Consultation Response from Mark Berry KC, Highways Development Management
2022/92081 Land at, Huddersfield Road/Leeds Road, Birstall, Batley, WF17 9AA
Demolition of existing buildings and erection of retail food store with associated parking and landscaping
Date Responded: 4-10-2023. Responding Officer: Mark Berry Responding Ref: 13-3SE-33.

REV	DATE	DESCRIPTION
PROJECT		
LEEDS ROAD & HUDDERSFIELD ROAD, BIRSTALL		
TITLE		
BUS STOP RELOCATION PLAN		
SCALE		
NTS @ A3		
DRAWING		
1620 301		
DATE		
AUG 2023

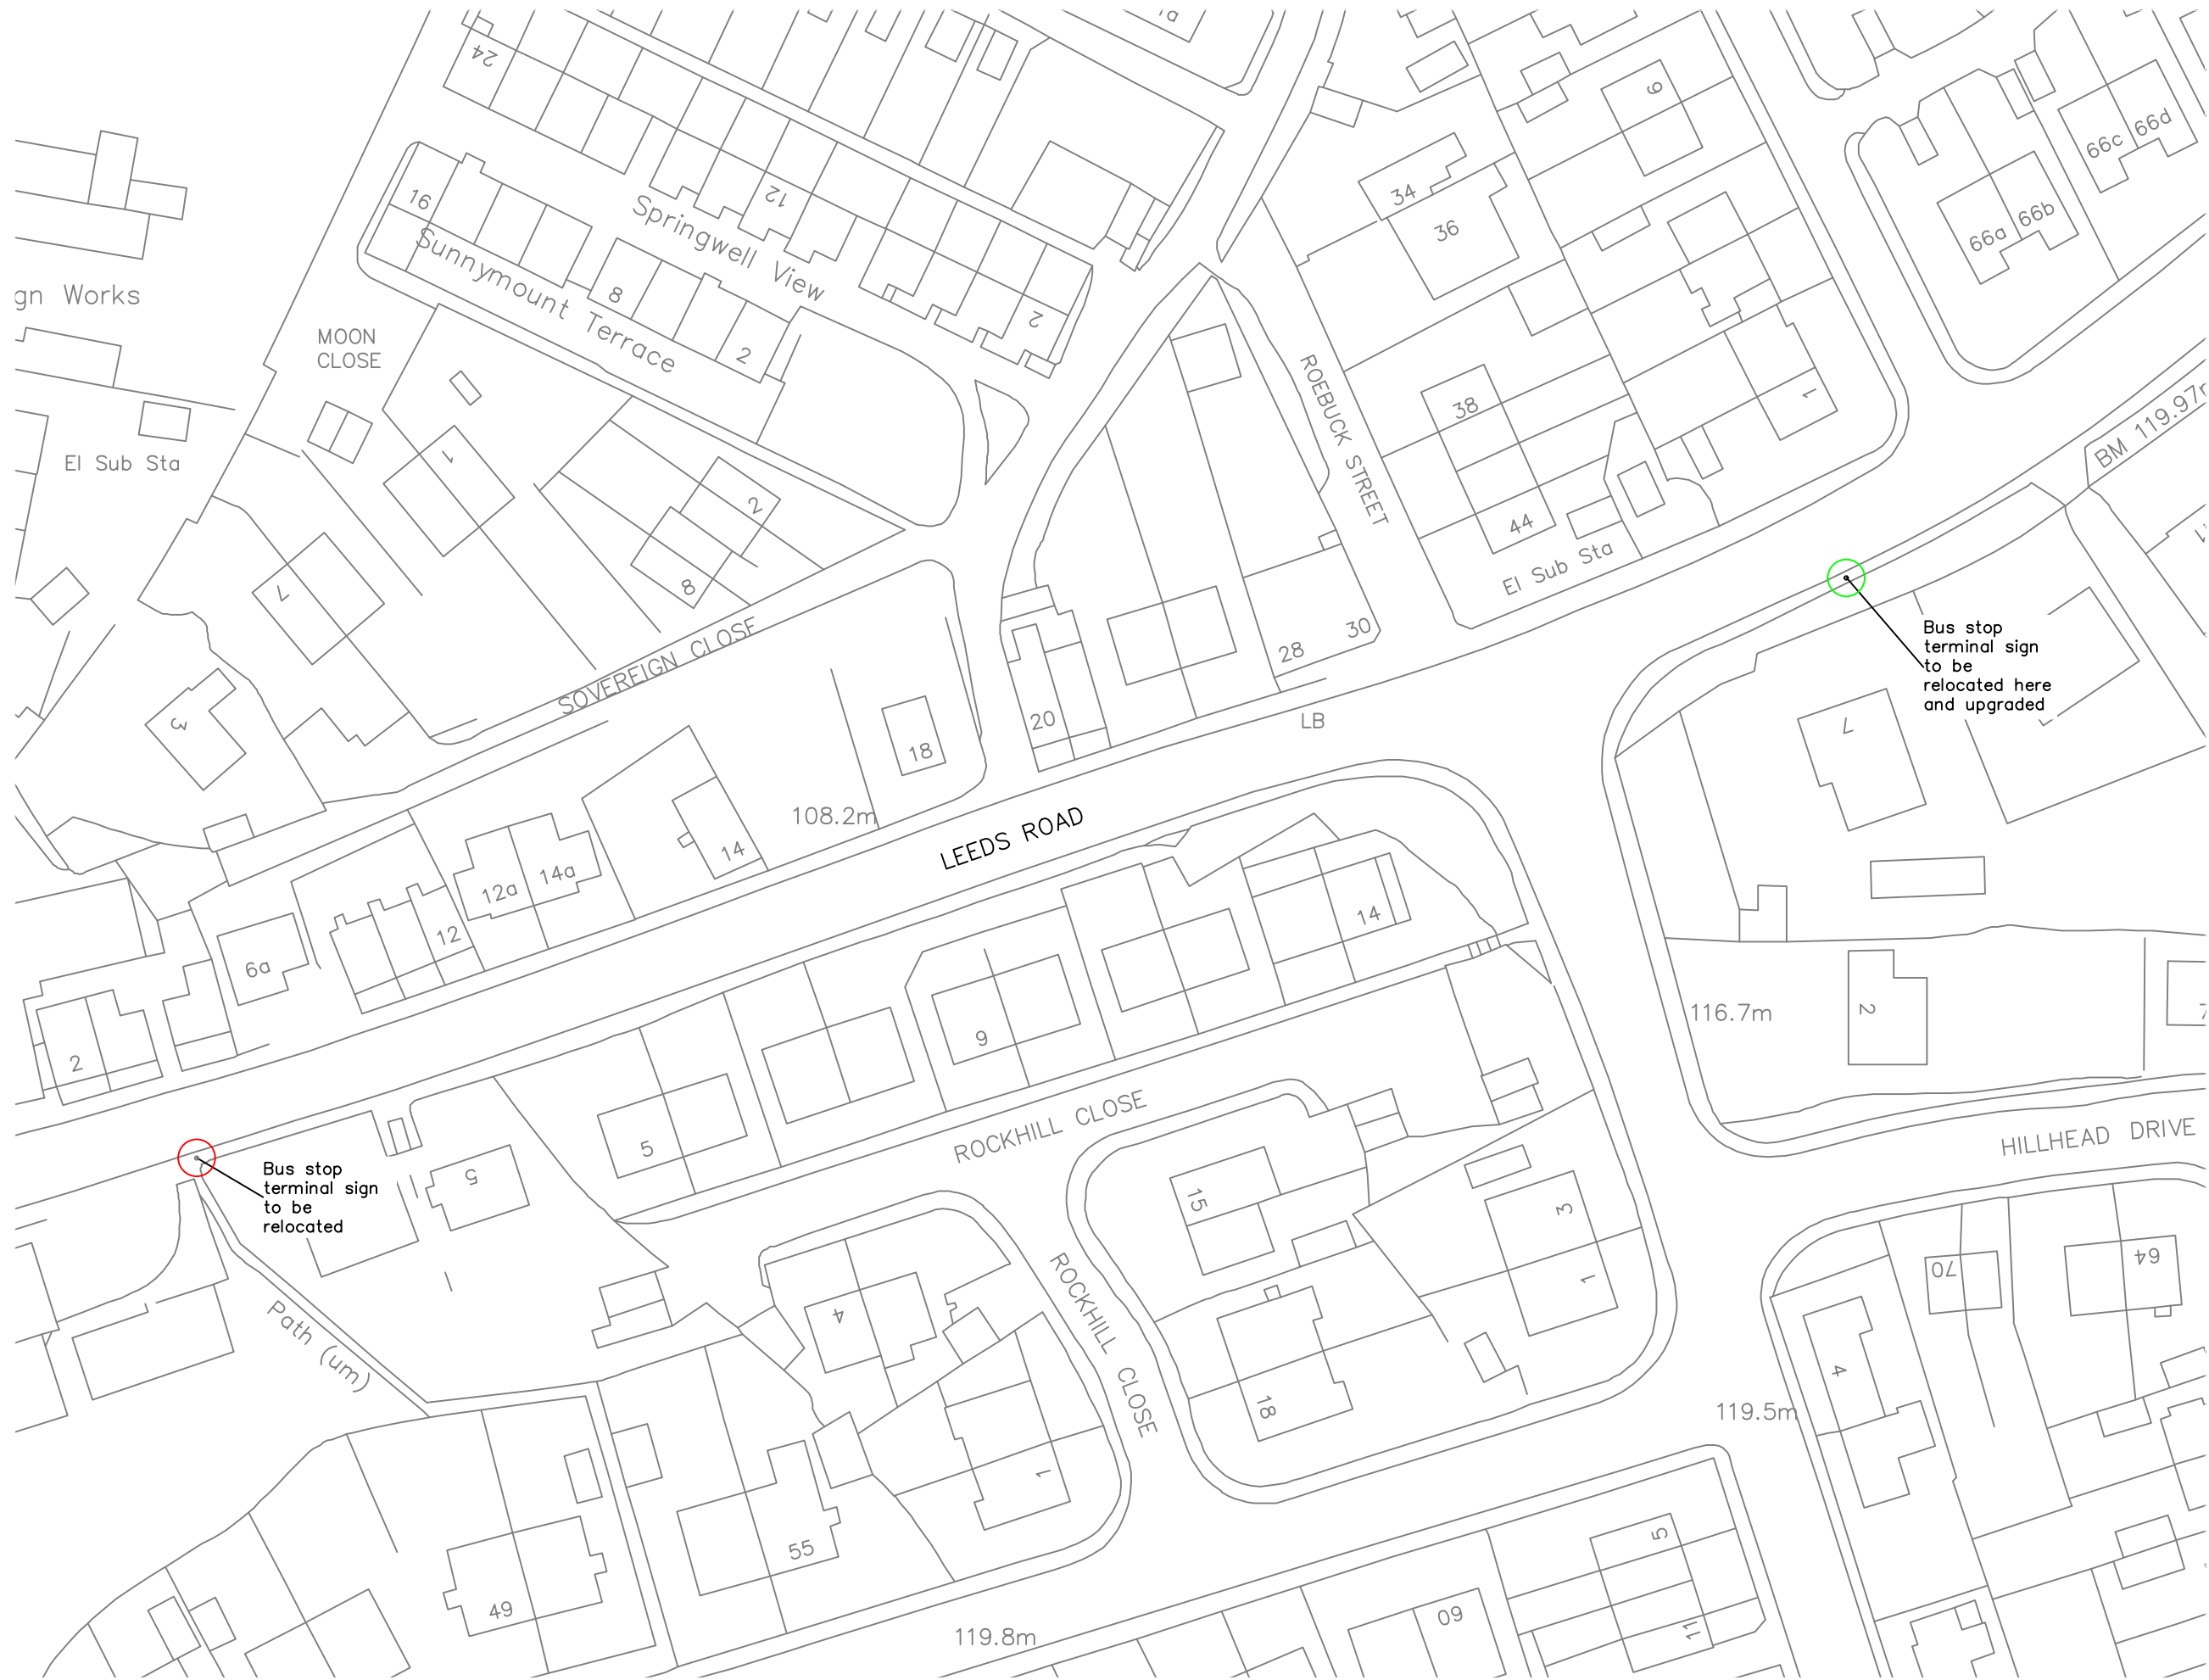
This shows the bus stop to be up graded and re-sited to the east of Upper Batley Lane. No detail of the proposal to up-grade the bus stop is provided.

West Yorkshire Combined Authority (WYCA) have been consulted regarding the proposed bus -stop re-site location and they have confirmed that the distance would be outside the government accessibility guidelines regarding the spacing between bus stops of approximately 200m.

The distance between the proposed location and the two most used bus stops are Birstall Market Place at 400m and Geldard Road/Nelson Street bus stop at 350m.

The current distances are Birstall Market Place 240m. Geldard Road/Nelson Street 170m.

Taking this into account WYCA must therefore advise that they do not support the relocation of the bus stop from its current location.
